STATE OF NORTH CAROLINA DEPARTMENT OF TRANSPORTATION

Addendum No. 2

RE: Contract # C203930 WBS # 46479.3.1 STATE FUNDED Currituck-Dare Counties (B-5937) Bridge #16 Over Currituck Sound On US-158 EBL

REVISIONS						SHEET NO.
NO.	BY:	DATE:	NO.	BY:	DATE:	TOTAL SHEETS
1			3			S-268
2			4

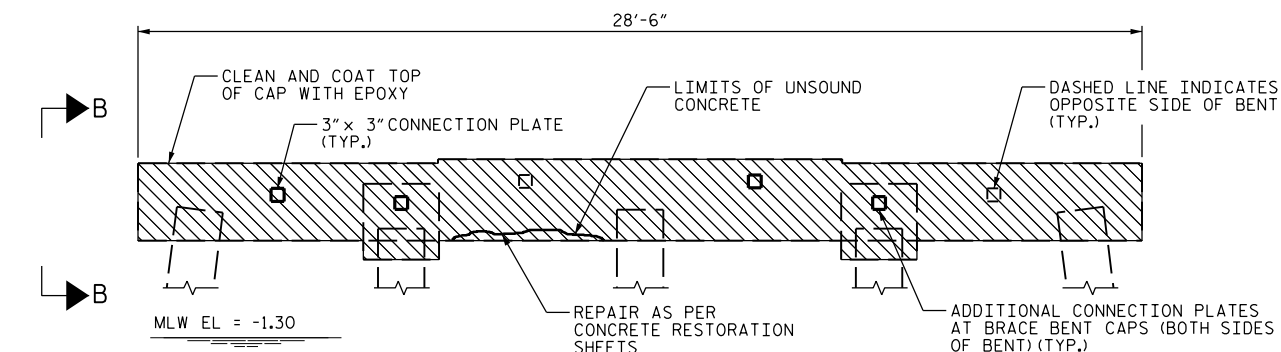
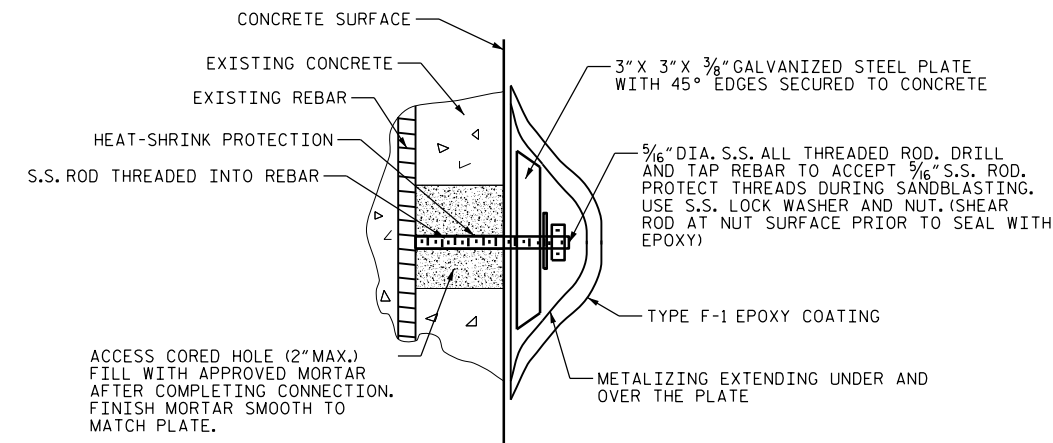
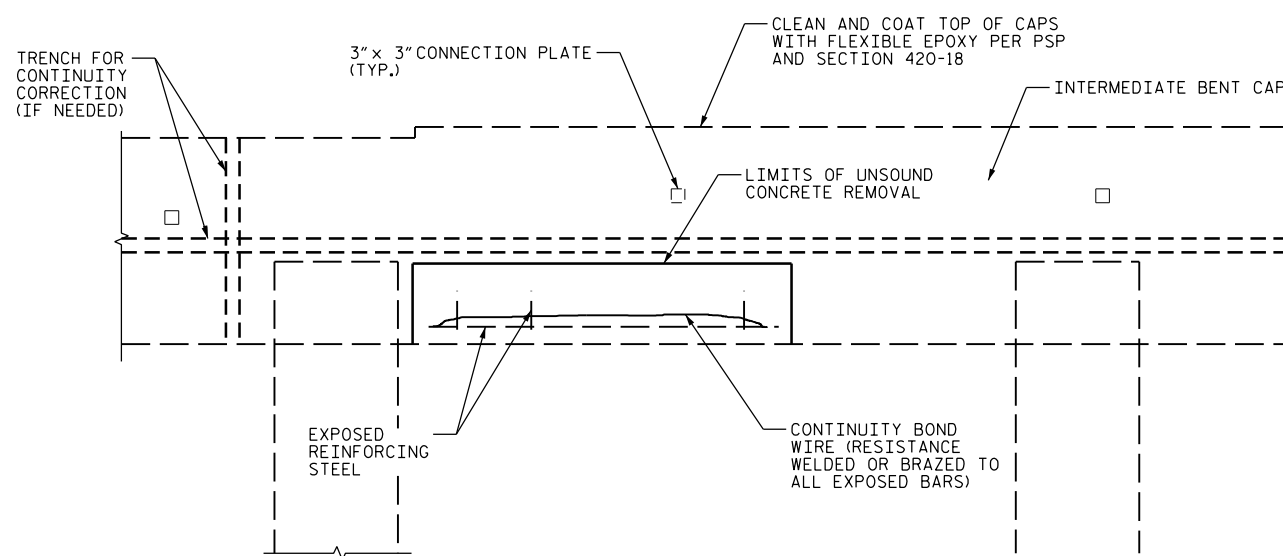
Sheet No.	Revisions	
S-1	Revised the Summary of Quantities to reflect the addition of the two	
	below mentioned pay items	
S-268	Revised note #4 to include reference to "Epoxy Injection of Cracks"	
S-273	Revised the Sheet No.(bottom right corner) to add the "S"	
S-284	Revised Note #3 to remove reference to replacing bearings
